Planning & Urban Development Department

October 30, 2014

RE: 25 Deane Street – 051-A-022 & 23 – R-5 Zone

Plan Depicting The Results Of A Standard Boundary Survey Made For
Julian D. Thomka-Cazdik
At The Intersection of Deane Street & Granite Street
PORTLAND, MAINE

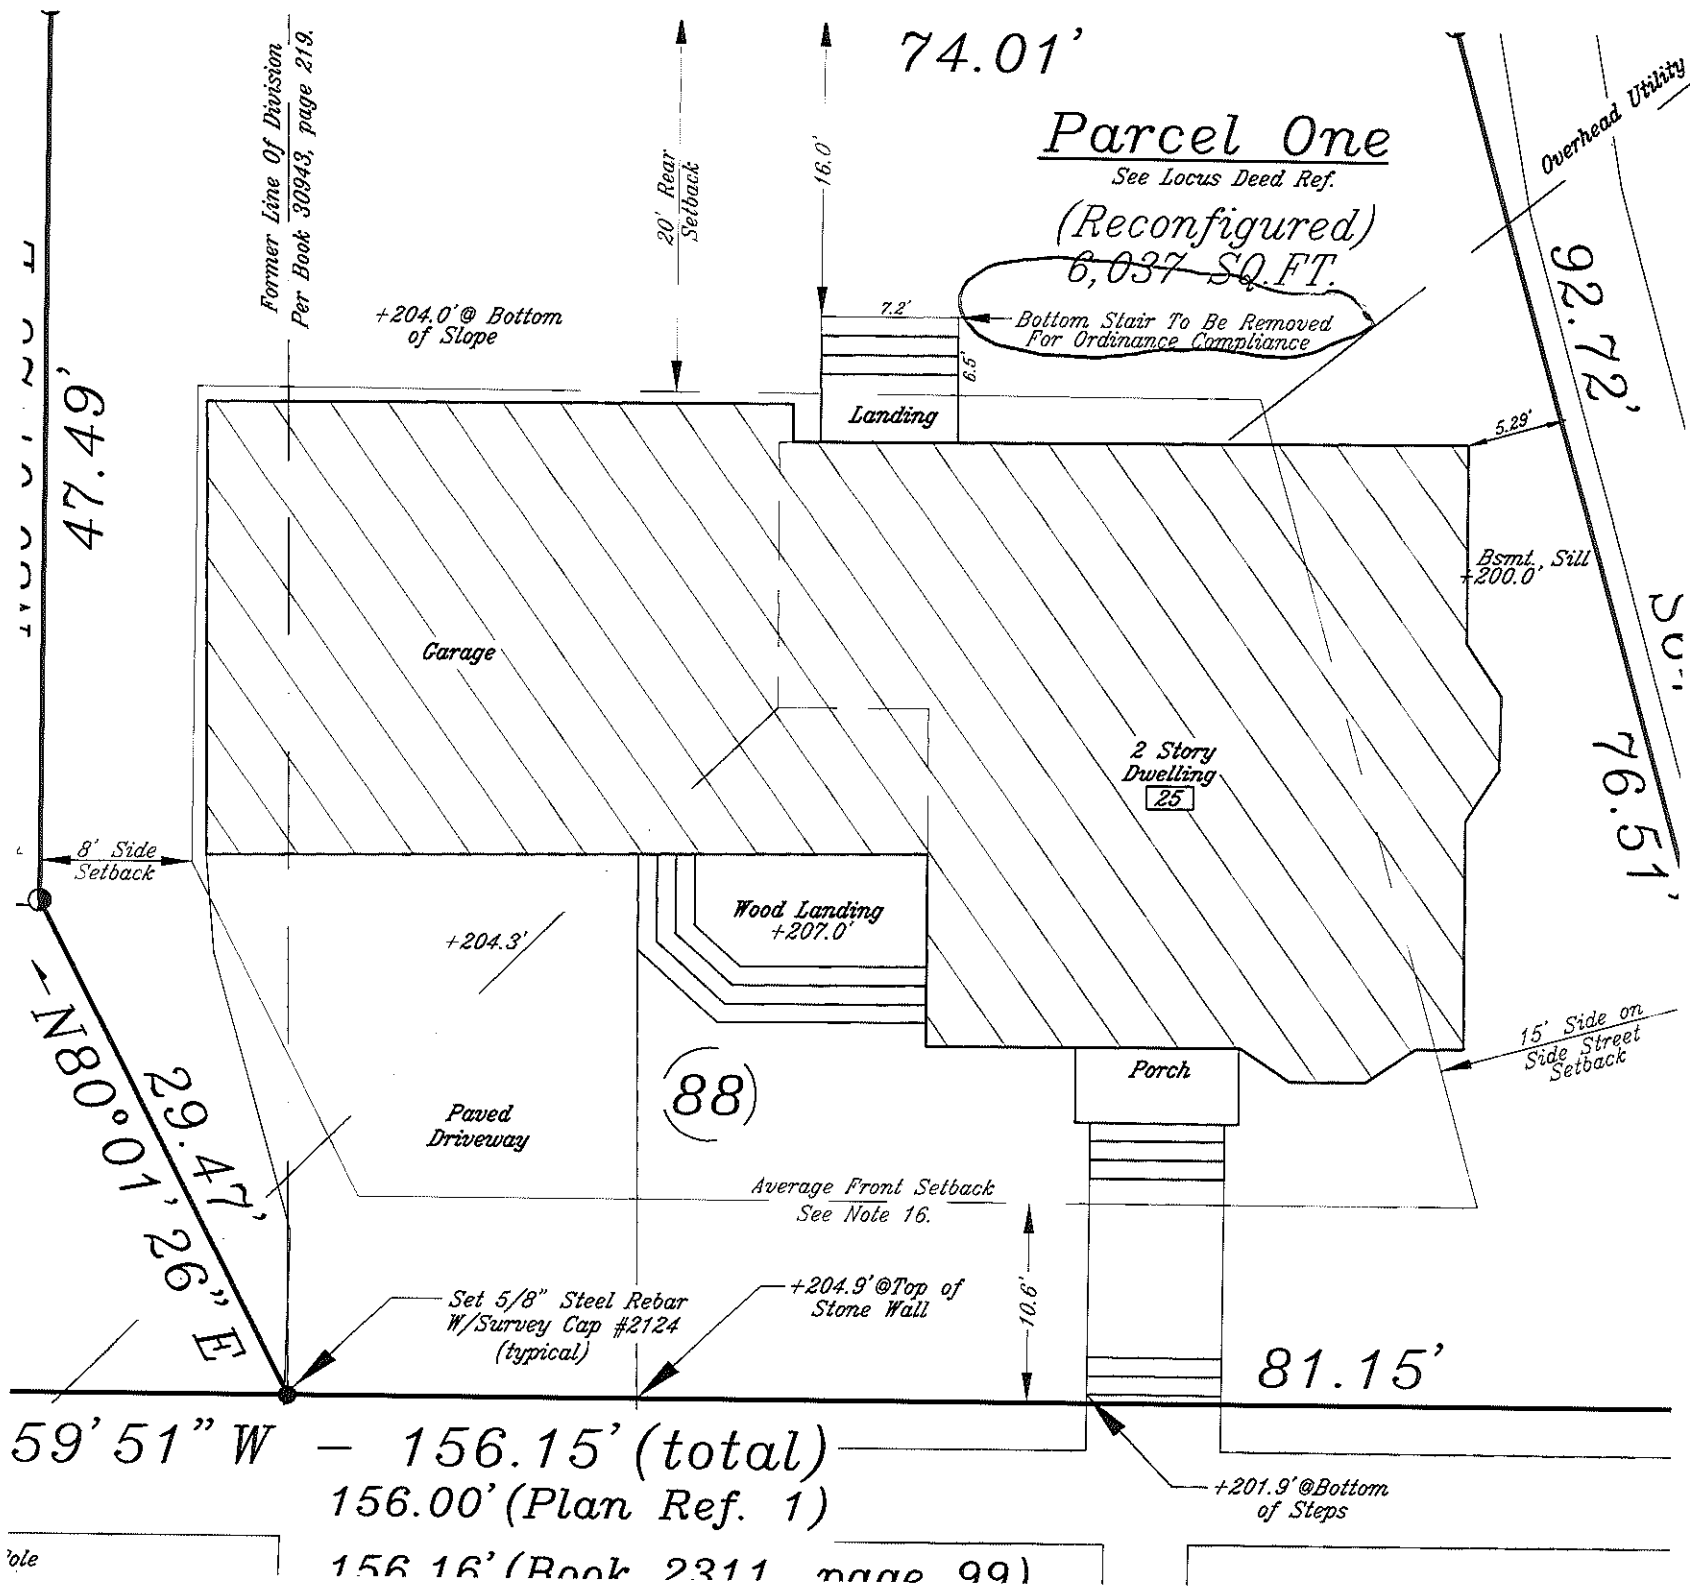
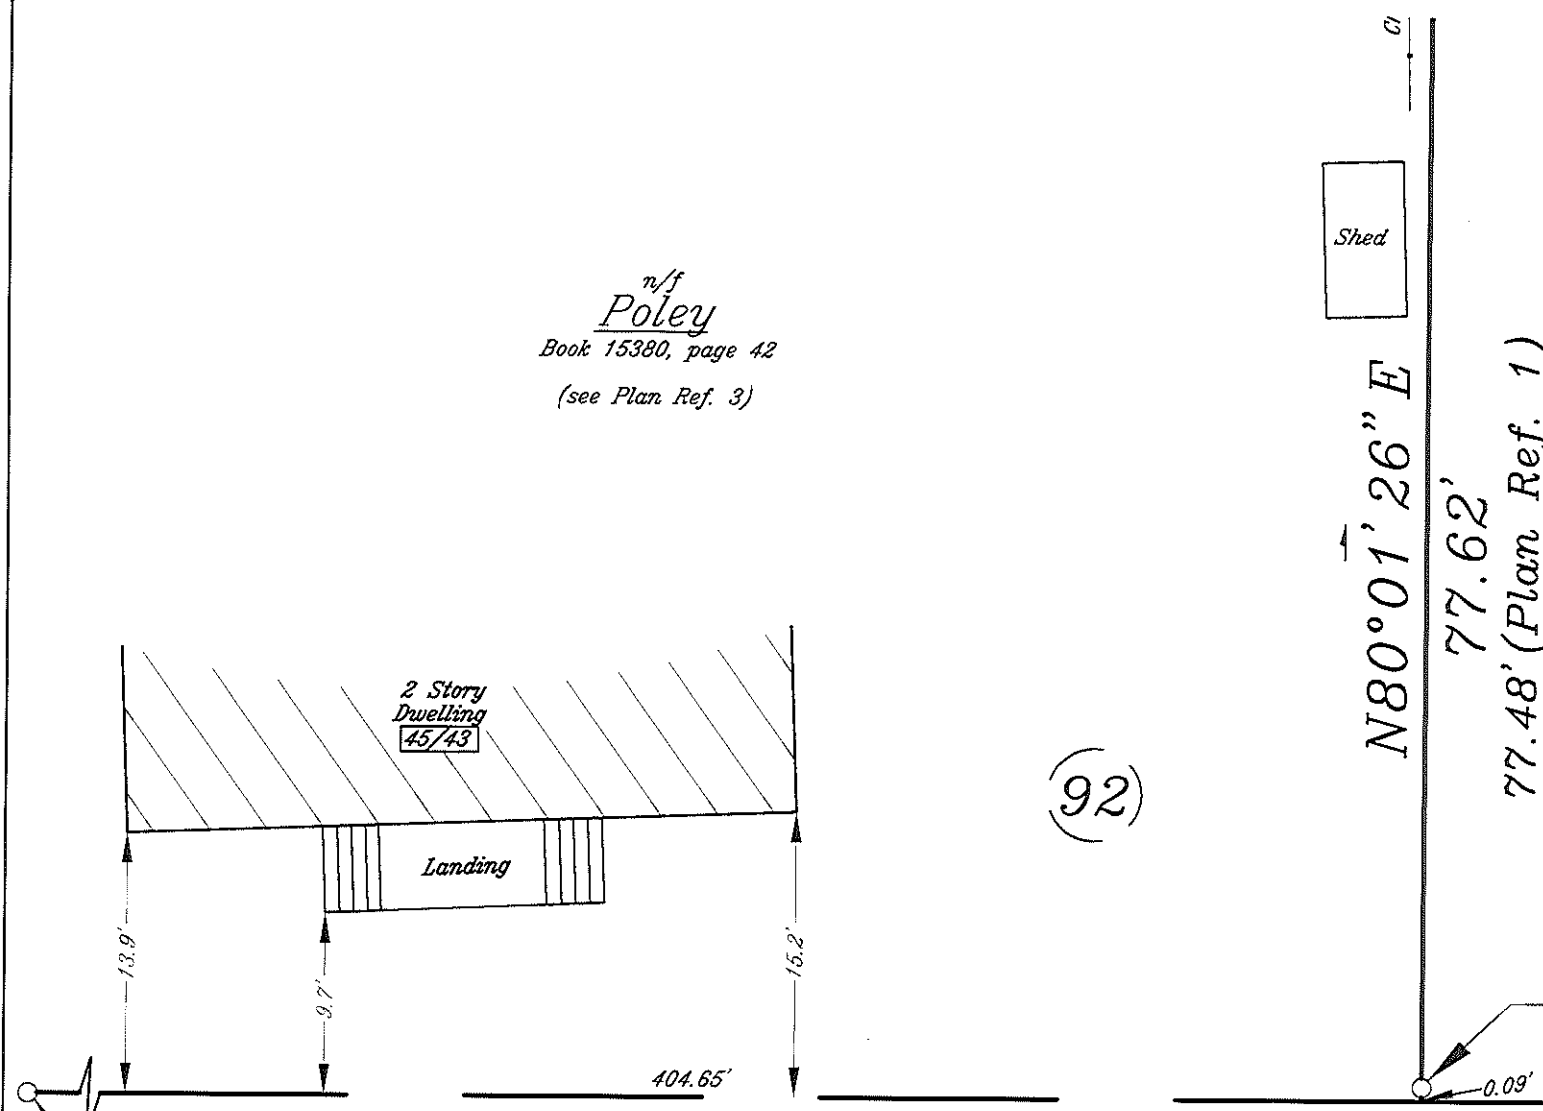
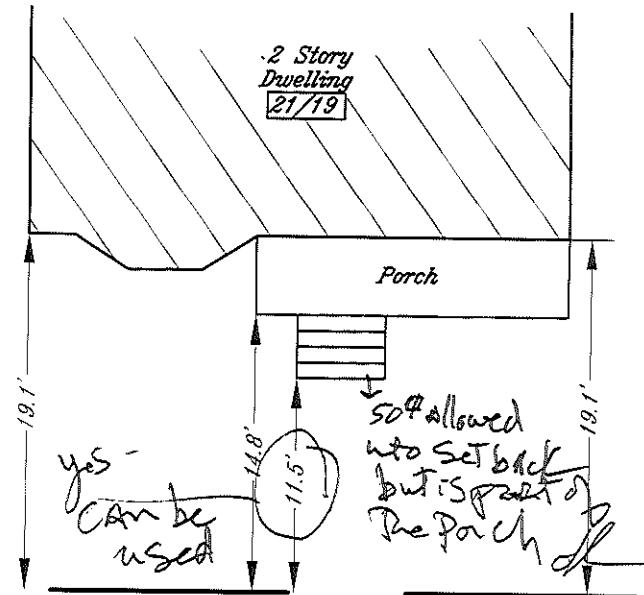
I am in receipt of your request for a zoning determination concerning 25 Deane Street. I have based my determination on a proposed, scalable survey, unsigned and unstamped performed by Nadeau Land Surveys. I have also been given a revised sketch survey on 10/21/14 that revises the rear landing and also revises the front yard averaging. The entire property is located in an R-5 residential zone.

The survey sketch received on 10/21/2014 also contains information concerning average front yard calculation. The calculations include setback information for the property to the left of Property Two and the first property to the right of Property One across Granite Street. This is the appropriate methodology for determining average setbacks. I agree with what is resulted for the average front yard setback.
